PEARTREE HILL SOLAR FARM DCO APPLICATION

COMPULSORY ACQUISITION HEARING 1

WRITTEN SUMMARY OF ORAL REPRESENTATIONS

### Figure 14.2: Transport Routing and the Existing Highway Network

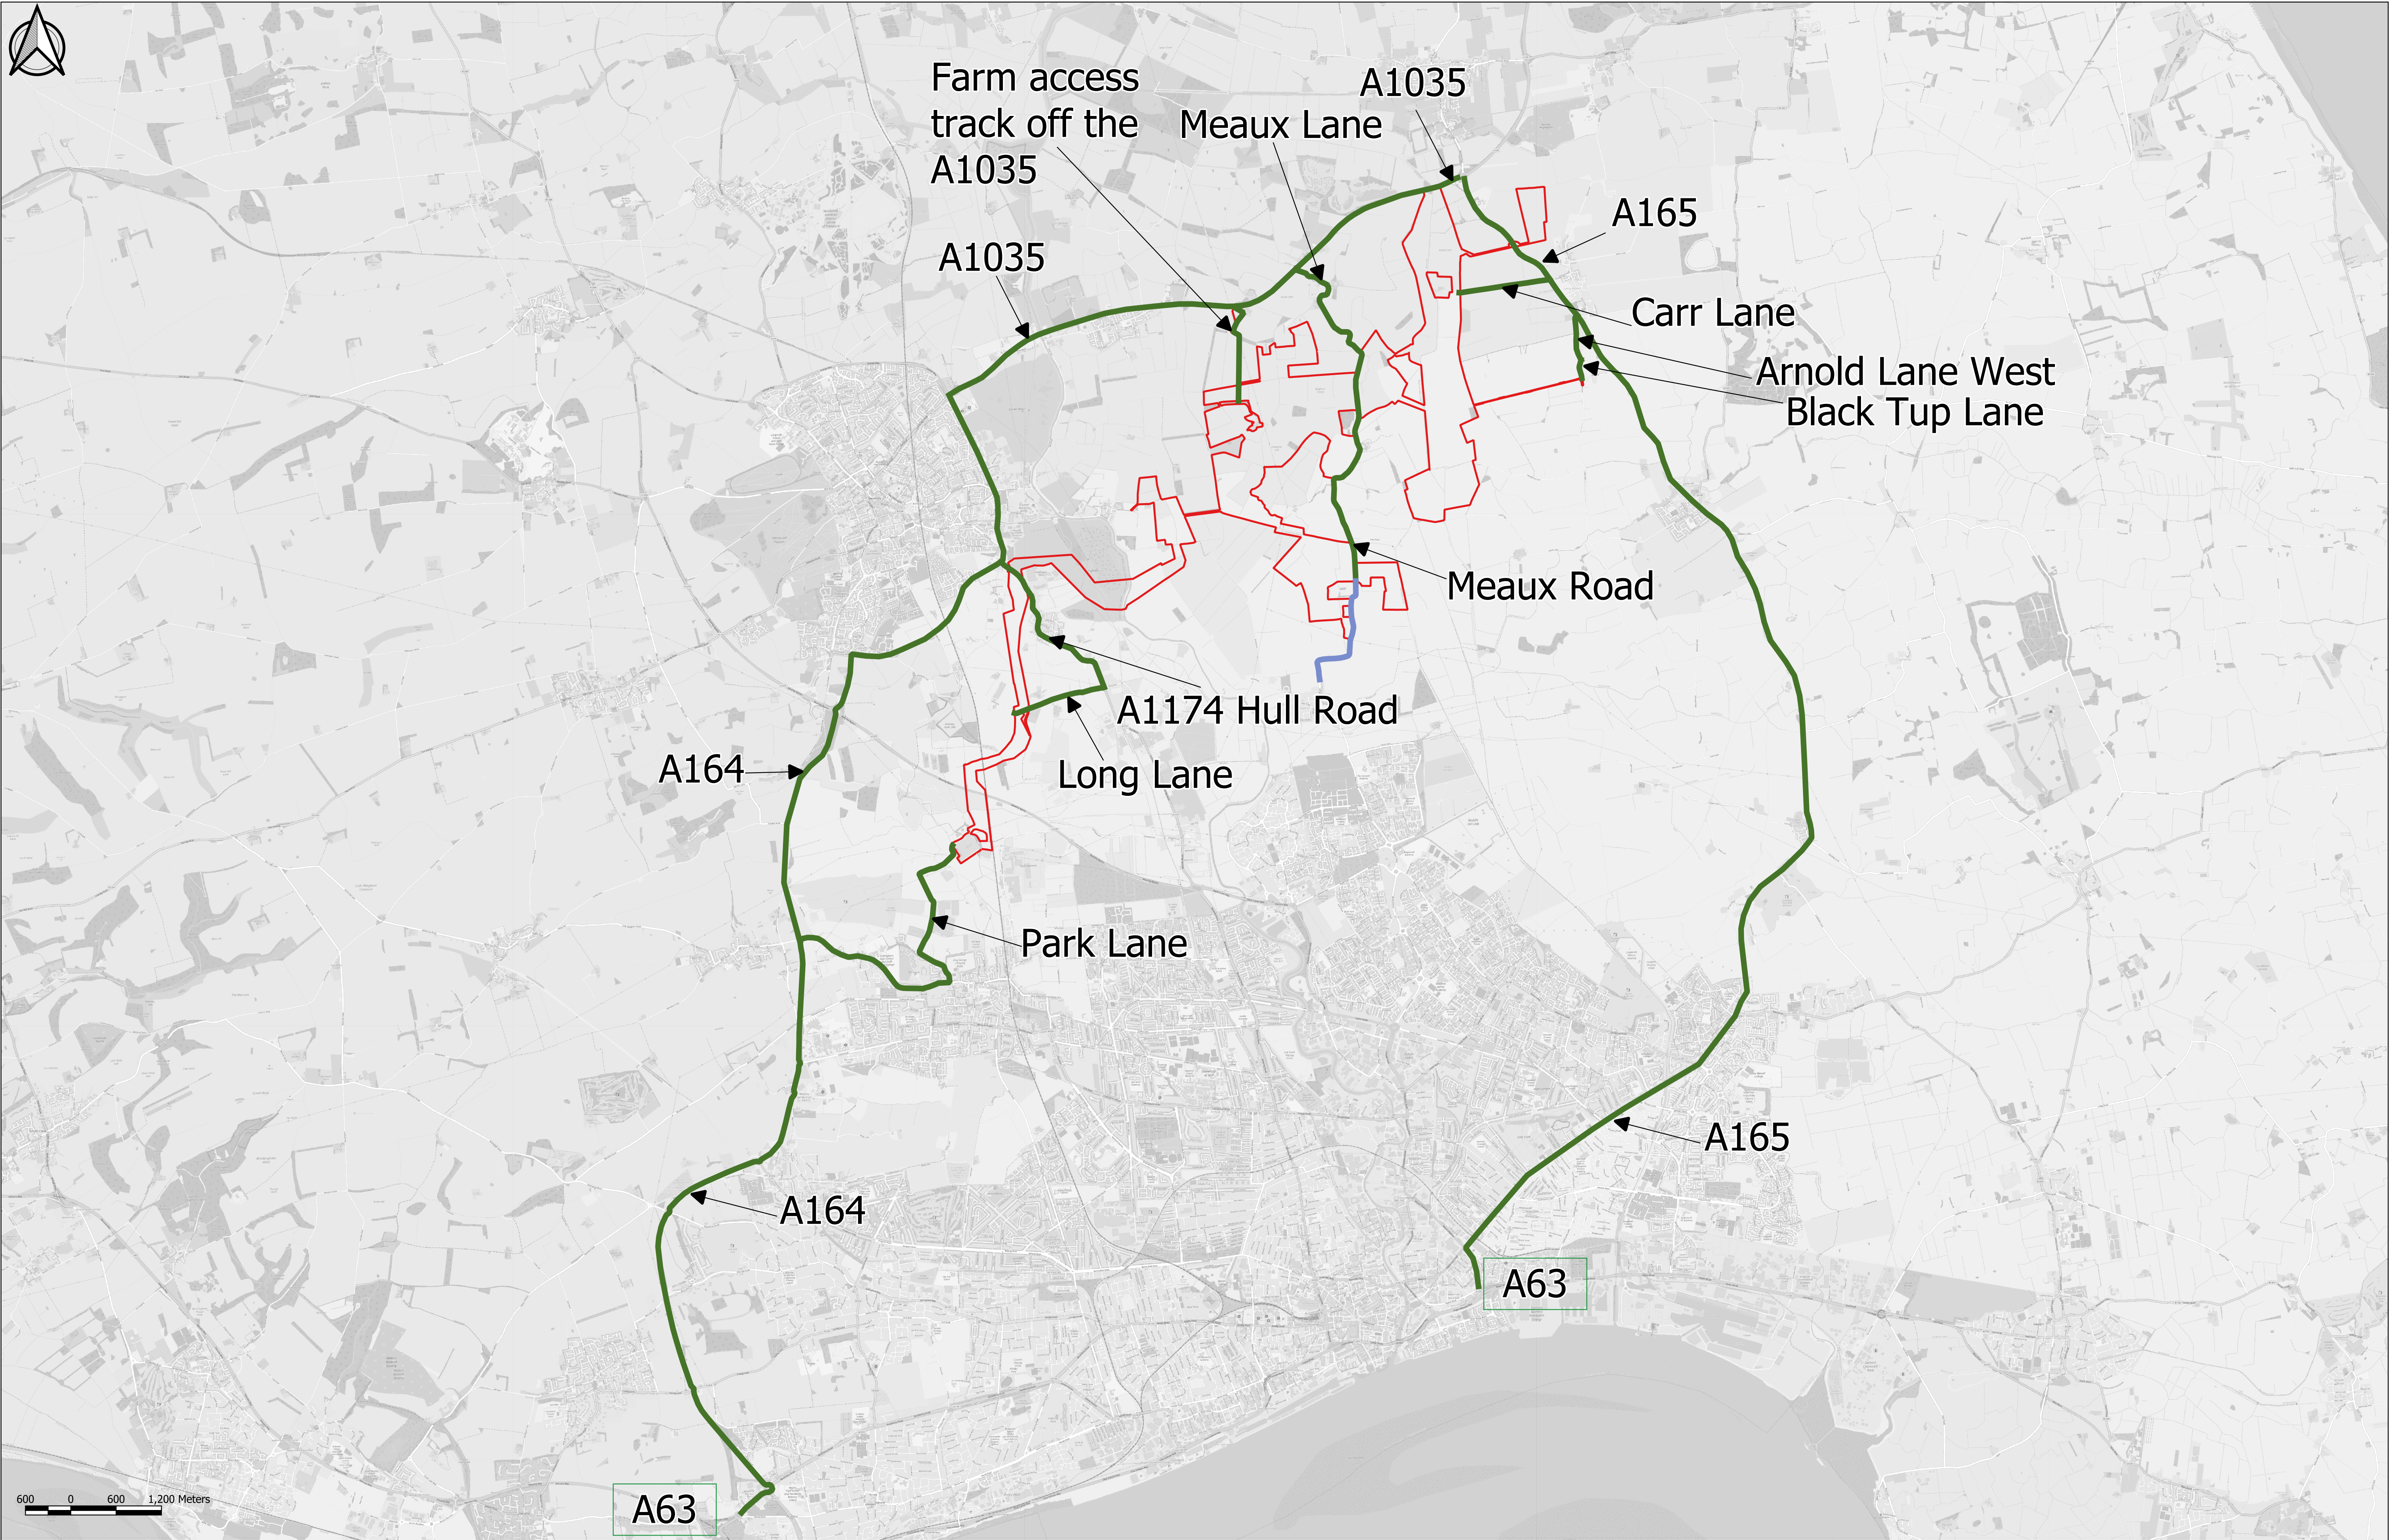
32. Two points should be noted.
33. First, Change 9 has been promoted on the basis of no baseline data having been collected for the private track, despite the applicant being well aware that this track serves:

- (1) Two solar farm schemes which are in the process of implementation;
 - (2) The properties at Field House Farm; and
 - (3) Albanwise’s 360 ha. Agricultural holding to the south;

34. Yes, despite this, the absurd assumption is made that the farm track is not currently subject to **any** use whatsoever. Cumulative use and therefore cumulative effects have been entirely ignored.

35. This is the basis on which the ES concludes that there would be no significant environmental effects. This is a major failing in terms of EIA. Until that assumption is revisited, rectified and re-consulted on (such that cumulative effects with the farming operations, FHF tenants’ use and 2 x solar schemes are considered) the ES does not provide a lawful basis to proceed with the changes. It is unreasonable and fails to provide the requisite environmental information to the ExA.

36. At this point, the highways implications of the junction arrangements including visibility splays etc. cannot be understood let alone tested and examined. Albanwise is therefore instructing its own transport engineer to provide a technical evidence-based assessment of matters which will be contained in its WRs. This will need to be examined (as will the applicant’s response to it) in the context of this examination –
